From: Connor Armi <connor.armi.hsy@colvilletribes.com>
Sent: Thursday, February 6, 2025 11:35 AM
To: Bradley Gasawski
Cc: Guy Moura; DAHP SEPA
Subject: Re: SD-24-00003 WDFW Matoon - Notice of Application

CDS is requesting comment on the following **shoreline substantial development** application: **SD-24-00003 WDFW Matoon**. Links to the file materials can be found below. The comment period will end **March 4, 2025, at 5pm**. CDS will assume your agency does not wish to provide comment if not received by this date. Please let me know if you have any issues accessing the materials.

RE: SD-24-00003 WDFW Matoon Lake shoreline substantial development
I-90, milepost 108.75 to 109.10, Lt.

TO: All Staff
FROM: Public Works Plan Review Team
DATE: March 3, 2025
SUBJECT: SD-24-00003 WDFW Matoon

CXT VAULT TOILET PLAN
NOT TO SCALE

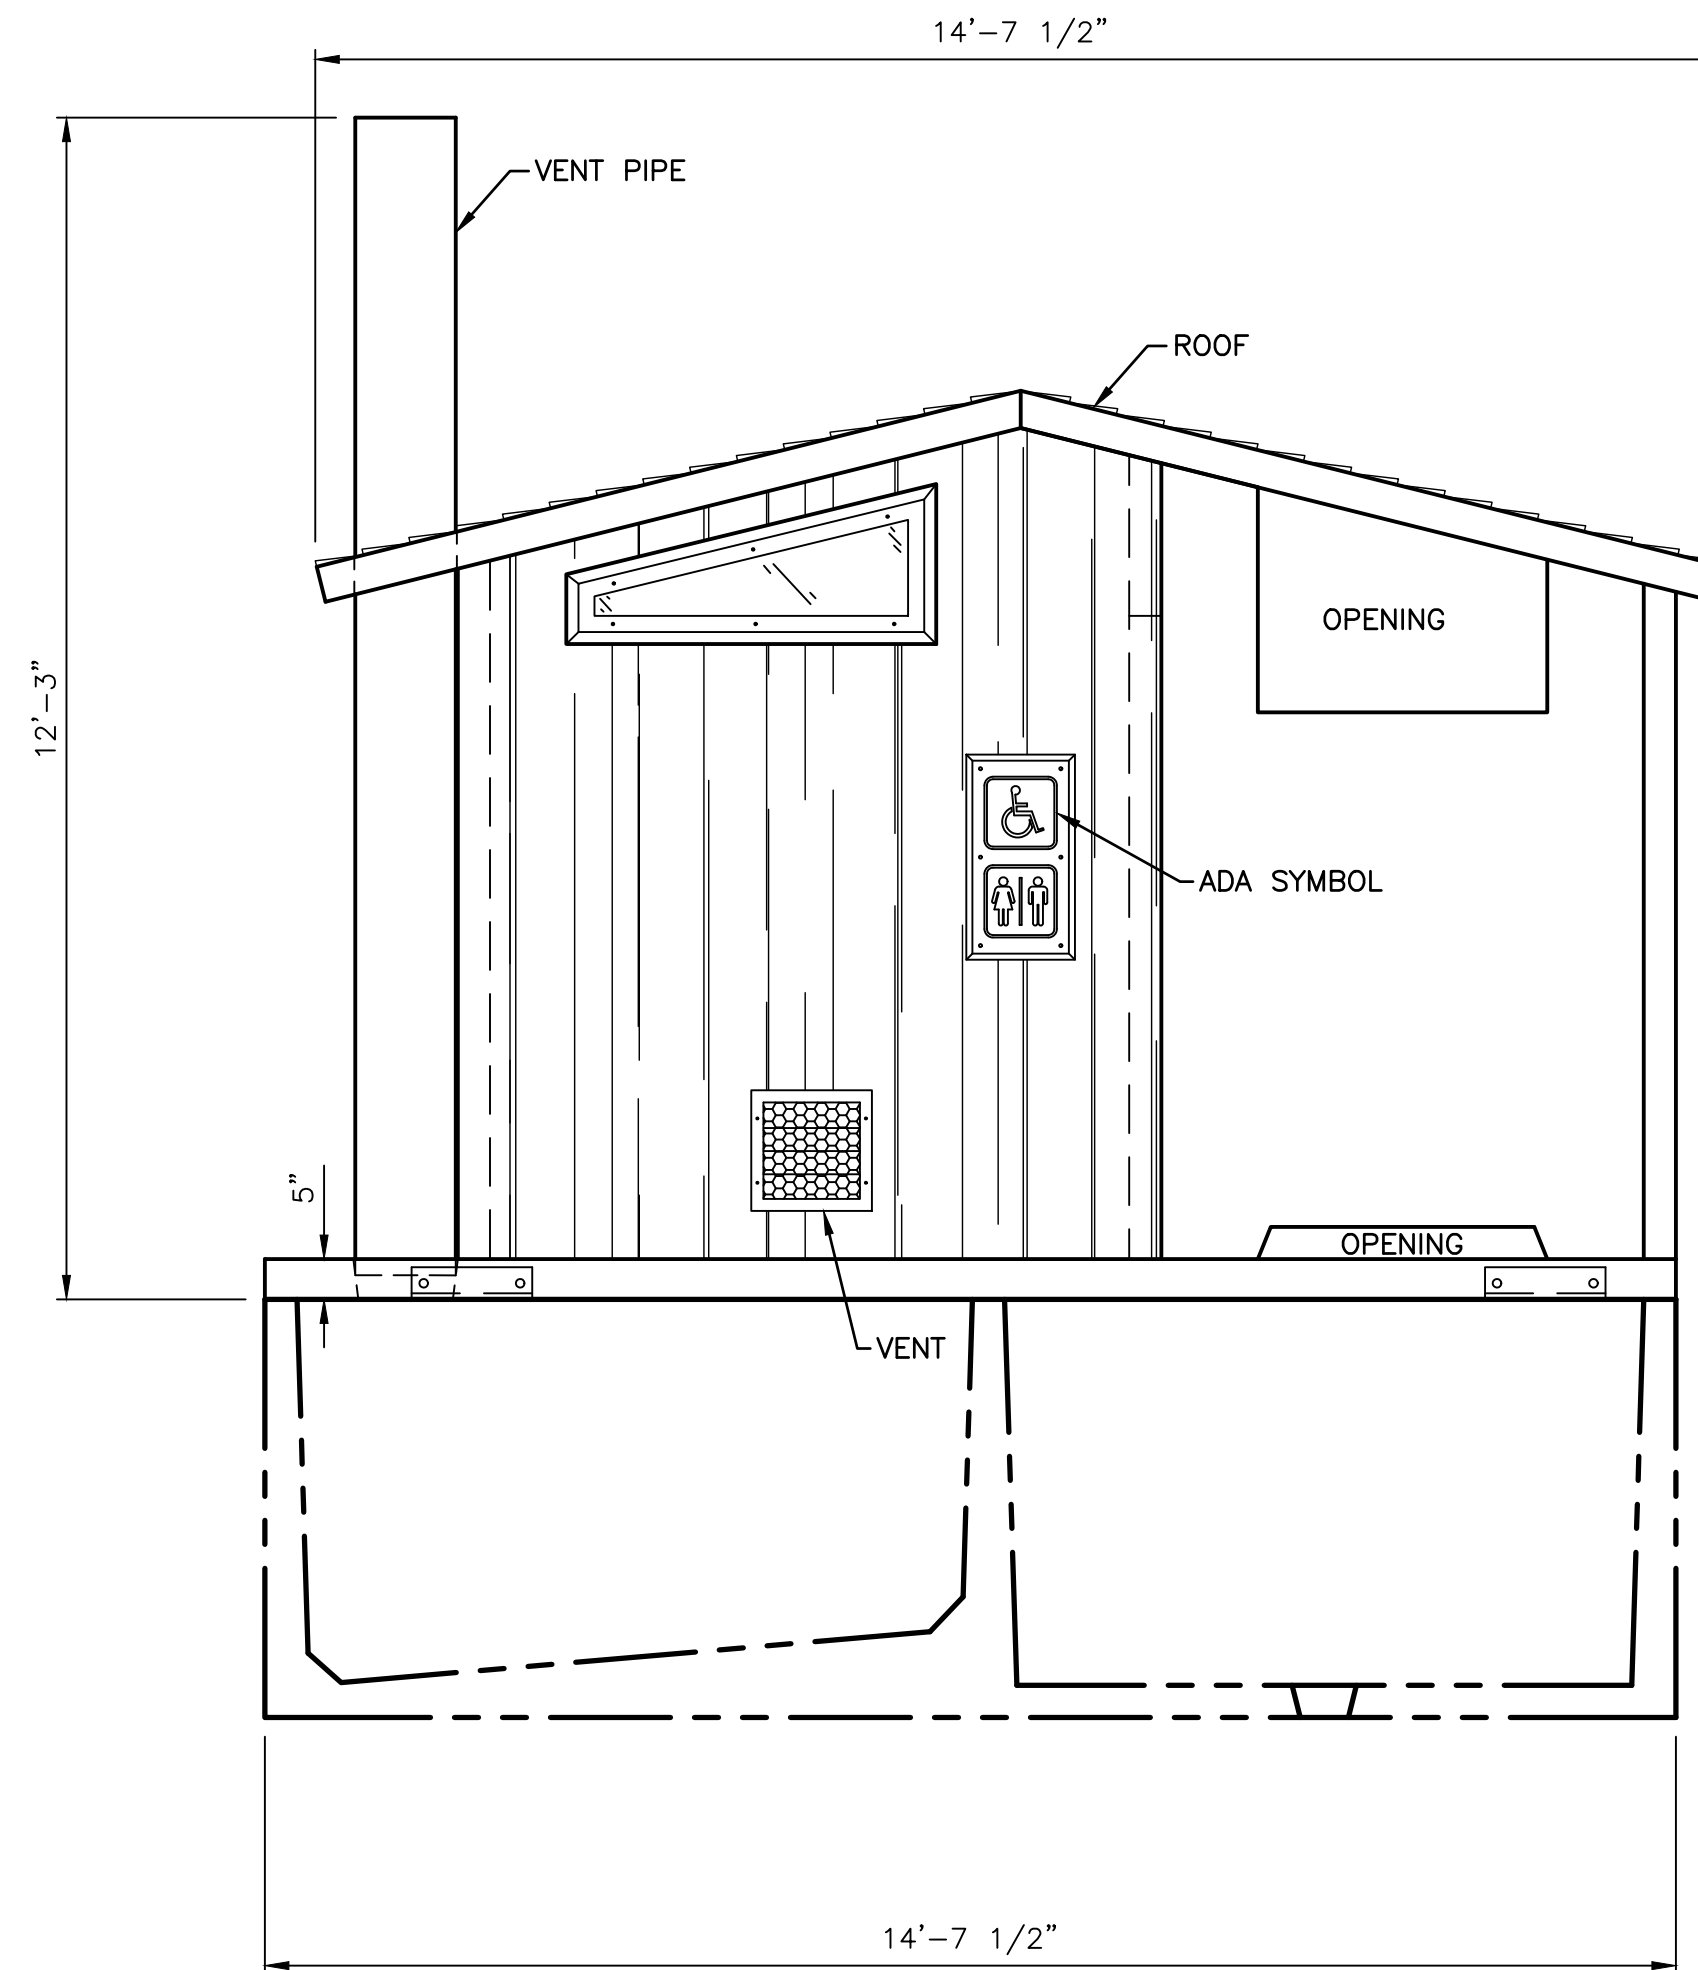
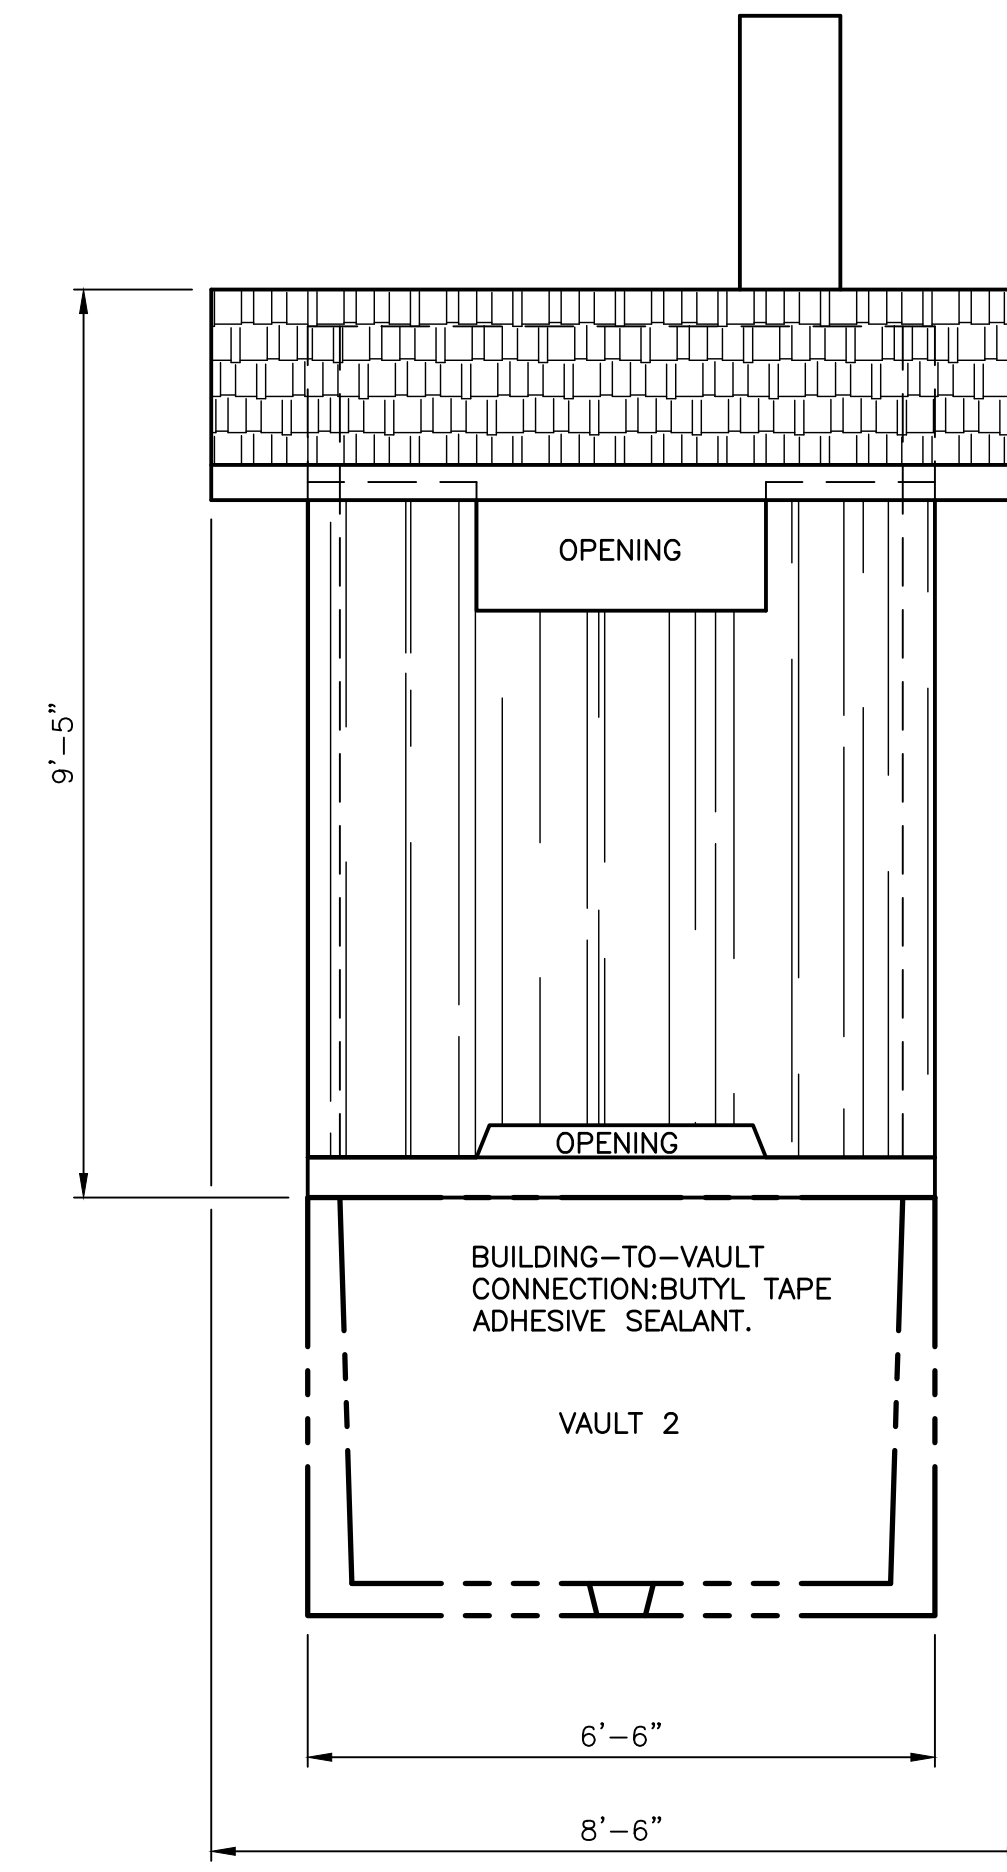
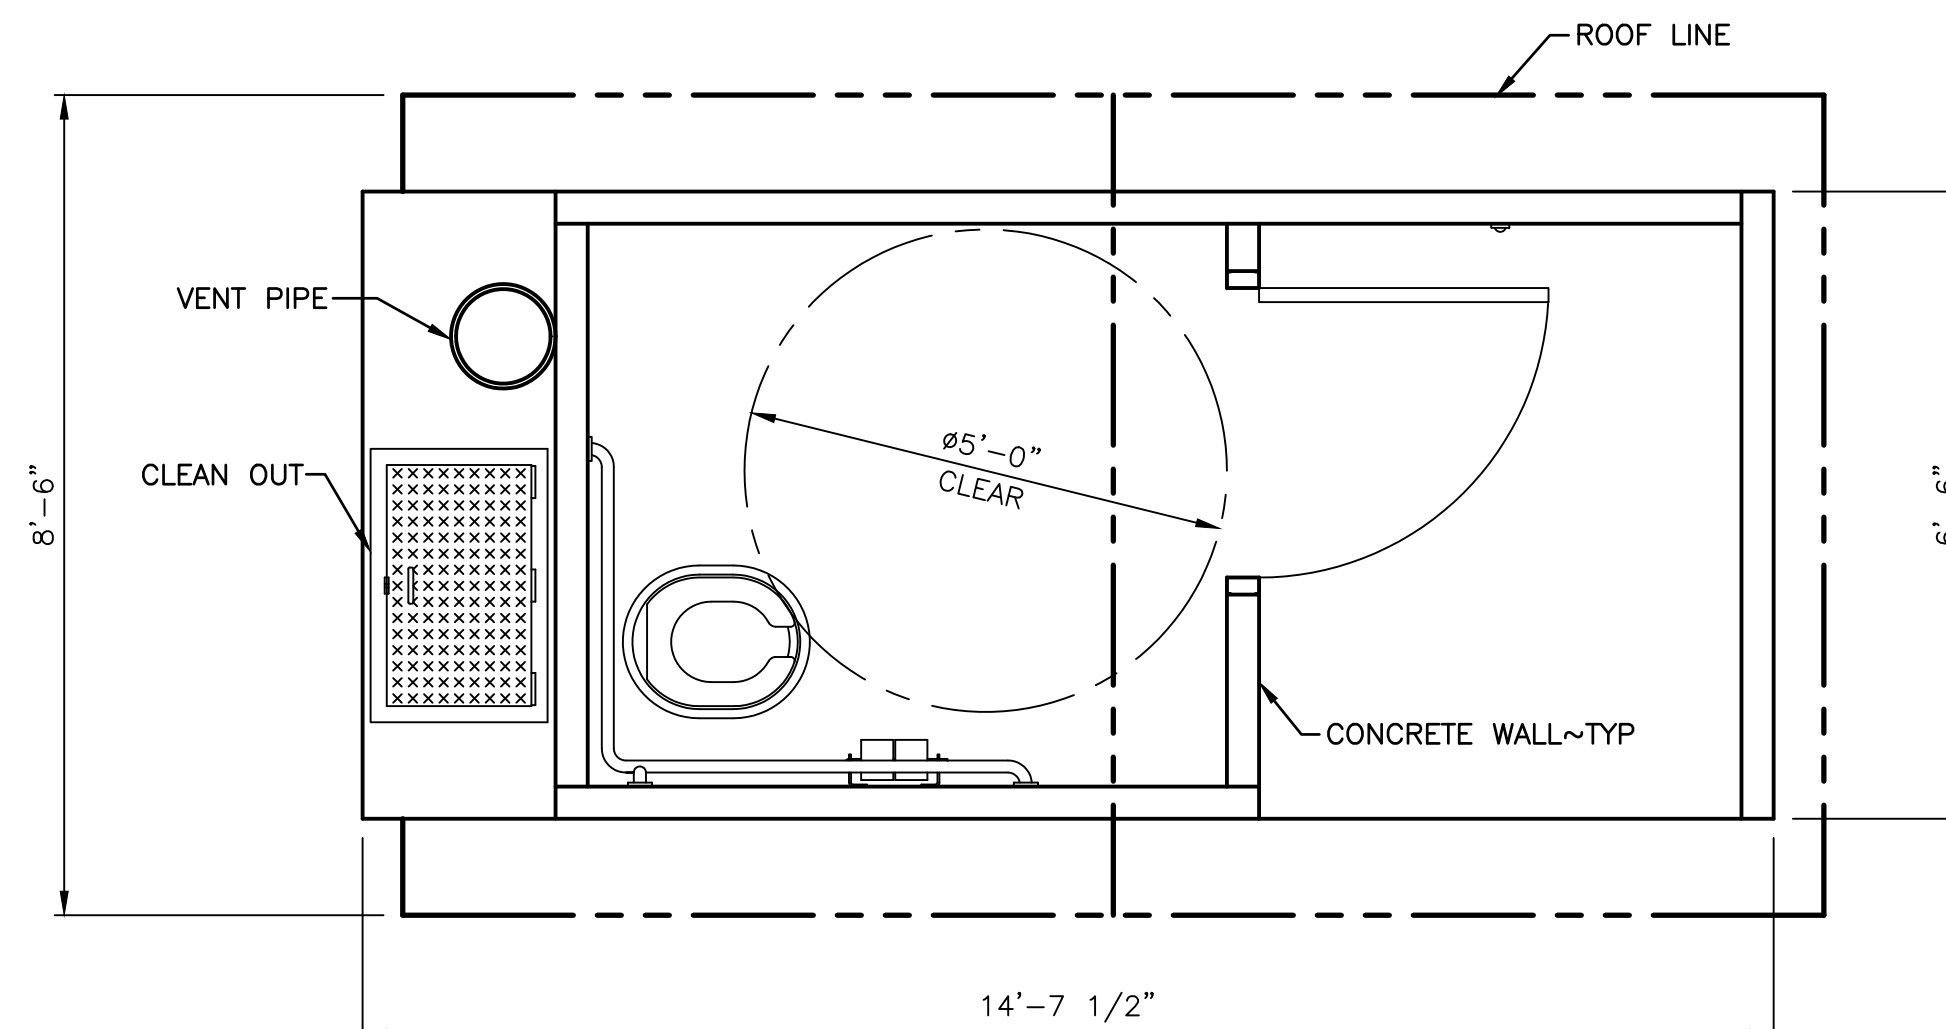
Drinking Water	No additional water will be provided. (DS)
Wastewater	<ul style="list-style-type: none">• Obtain a Privy/Compost Permit from Public Health to replace the existing vault toilet.• Provide a plan for the removal of the existing vault with the permit application. (DS)
